From: Colin Sharpe
Sent: 21 December 2011 15:45
To: planning
Subject: FW: Consultation on planning application 3/2011/0860 Old School Room, Walker Fold, Chaigley

The proposed access arrangements for this development represent a considerable improvement on the existing situation. I therefore have no objection to this proposal, subject to the following conditions:

Tarmac drive removed
and grassed over
with stone foot path

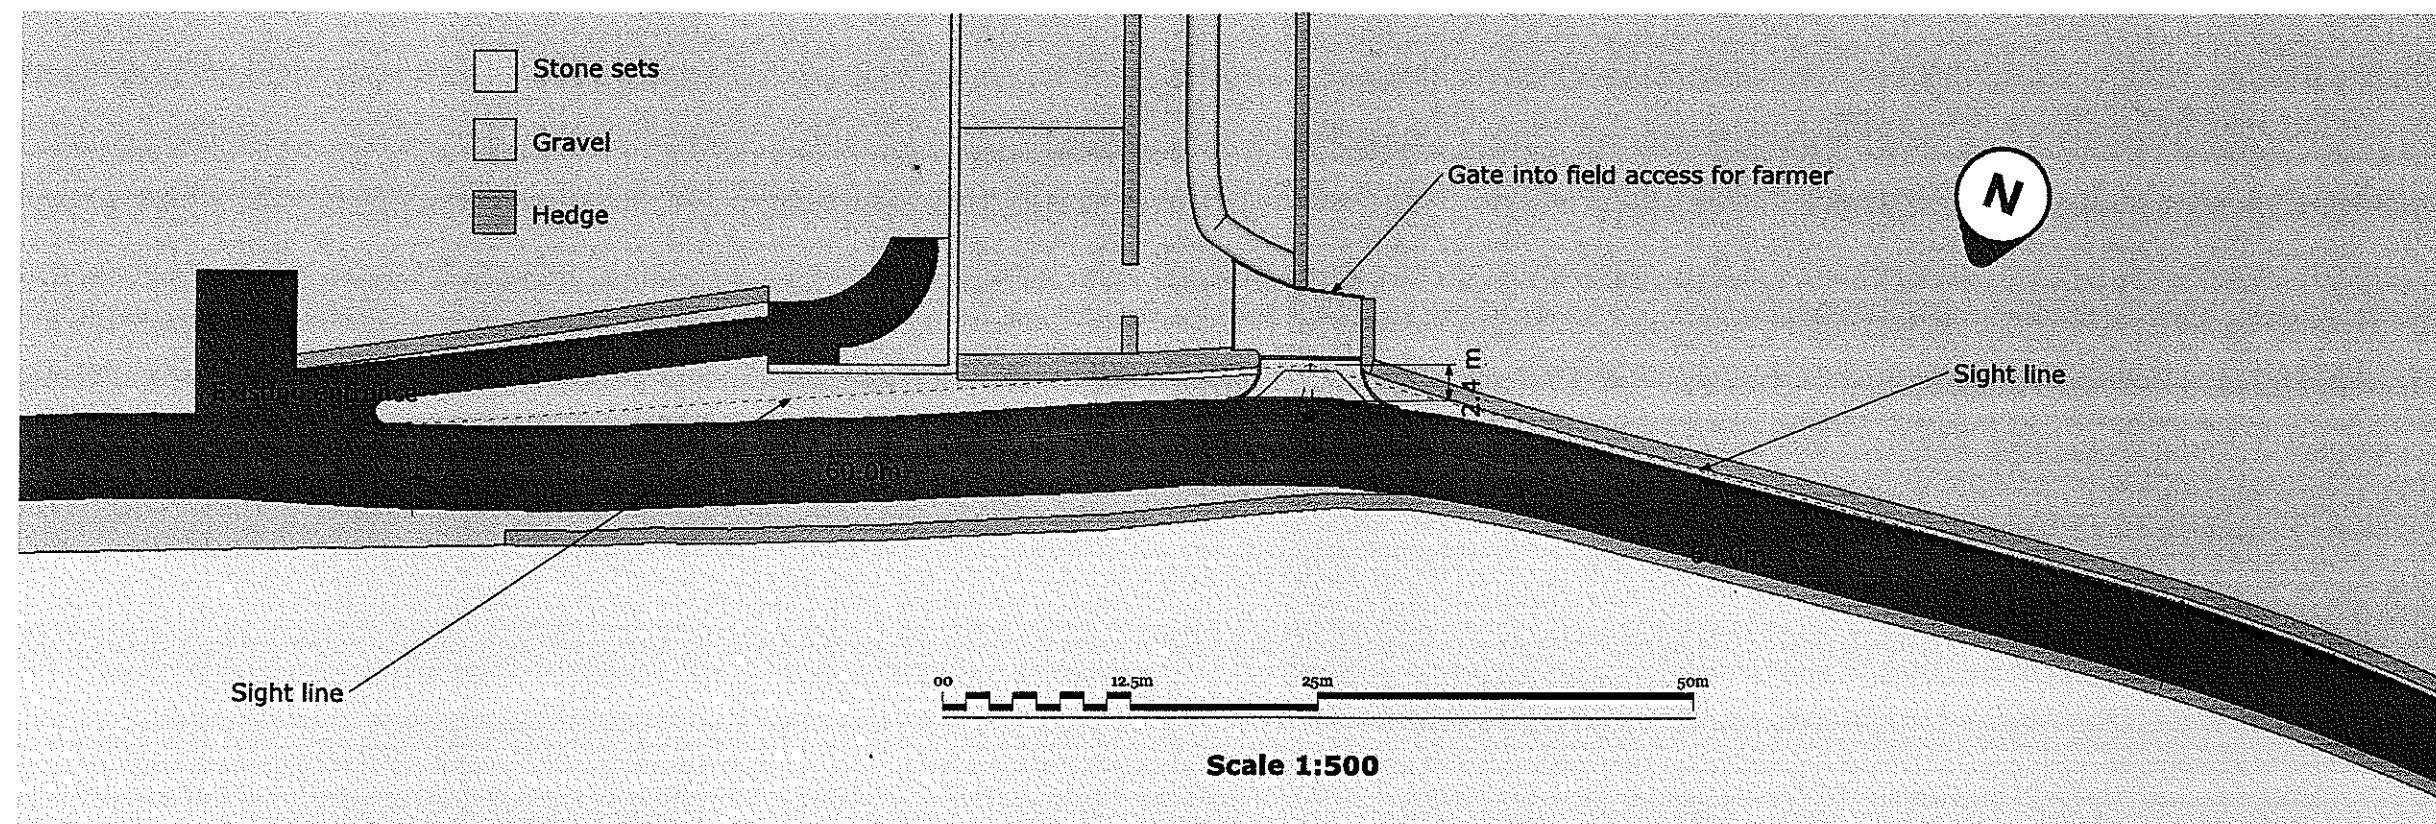
3. The existing access shall be physically and permanently closed and the verge over which the access crosses shall be reinstated. Reason: To limit the number of access points to the highway and in the interests of highway safety.

Details of new Vehicular Access, Old School Room, Walker Fold, Chaigley

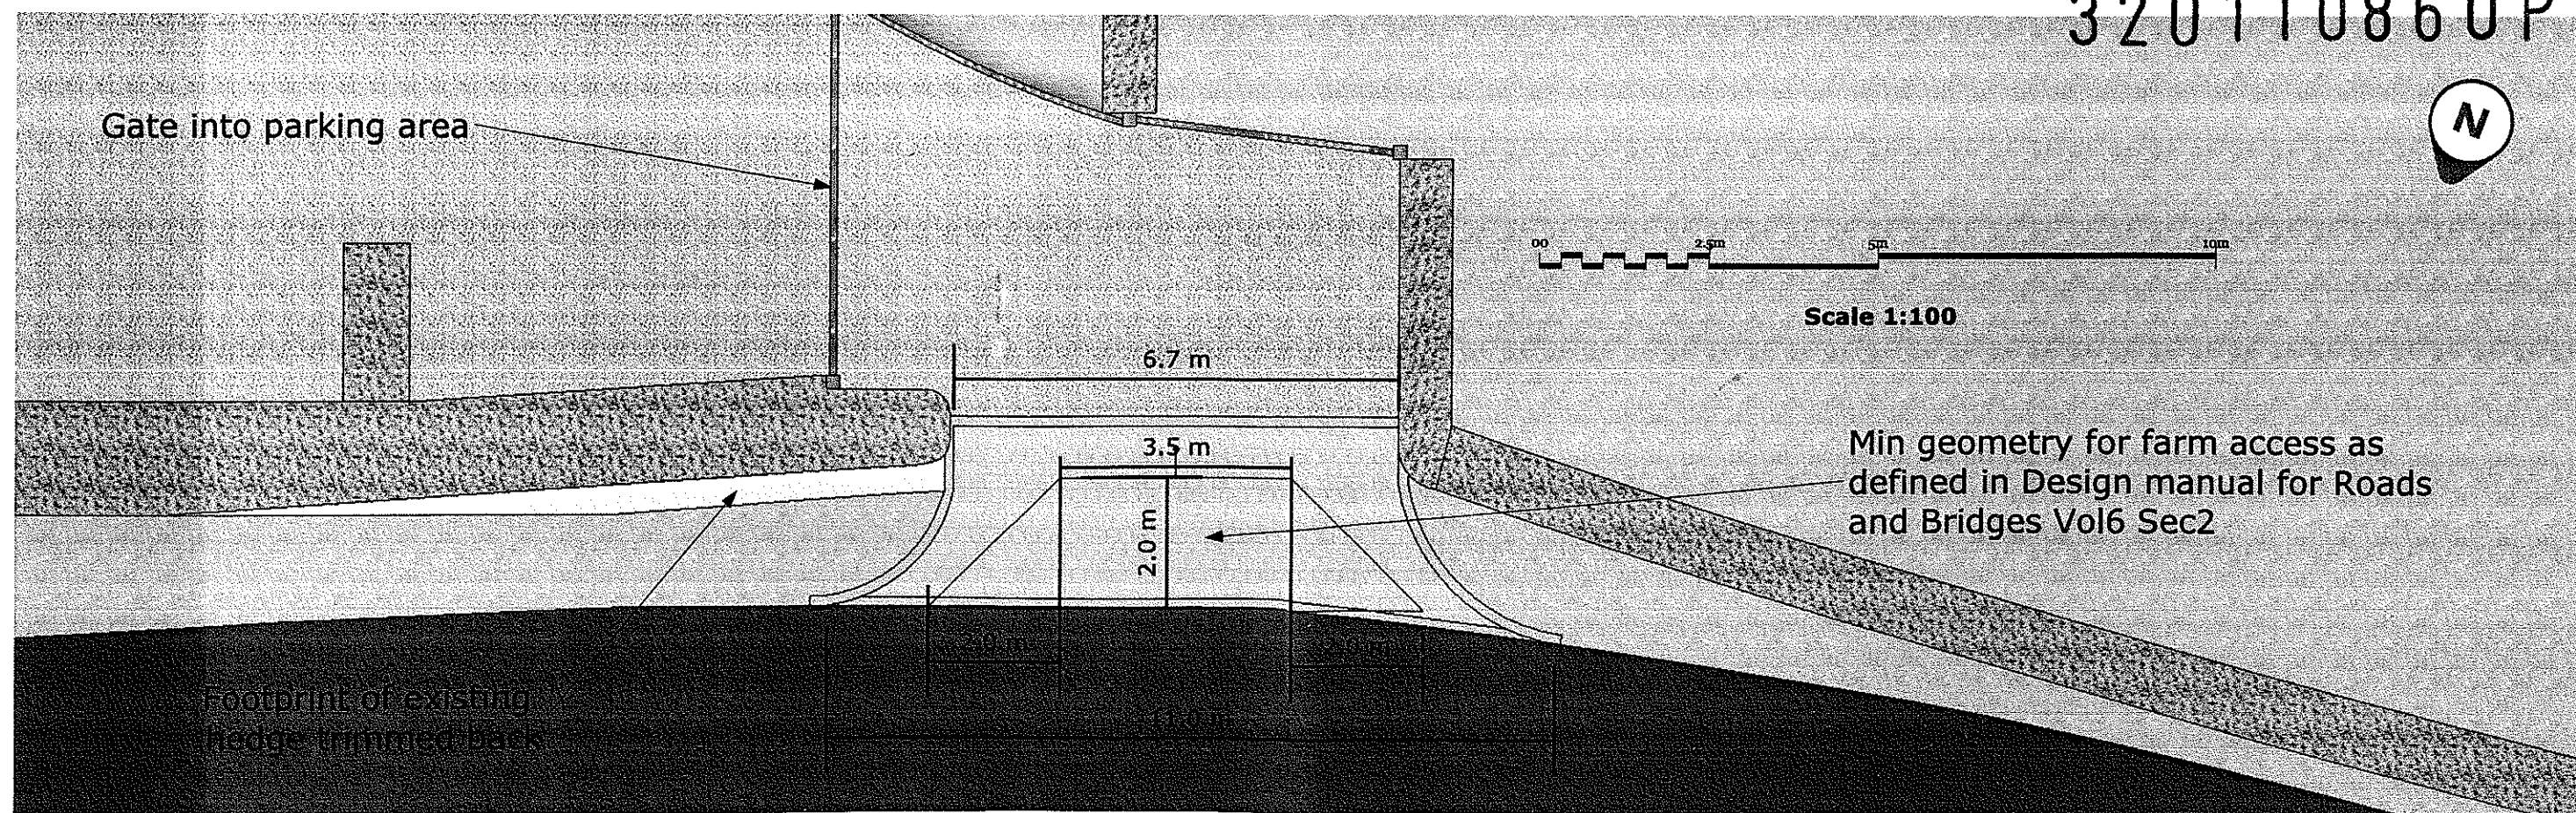
1. Before the proposed new access is used for vehicular purposes, any gateposts erected at the access shall be positioned a minimum of 5 metres behind the nearside edge of the carriageway of Longridge Road. The gates shall open away from the highway. Reason: To permit vehicles to pull clear of the carriageway when entering the site.

2. Before the proposed new access is used for vehicular purposes, that part of the access extending from the highway boundary for a minimum distance of 5 metres into the site shall be appropriately paved in tarmacadam, concrete, block pavements, or other approved materials. Reason: To prevent loose surface material from being carried onto the public highway thus causing a potential source of danger to other road users.
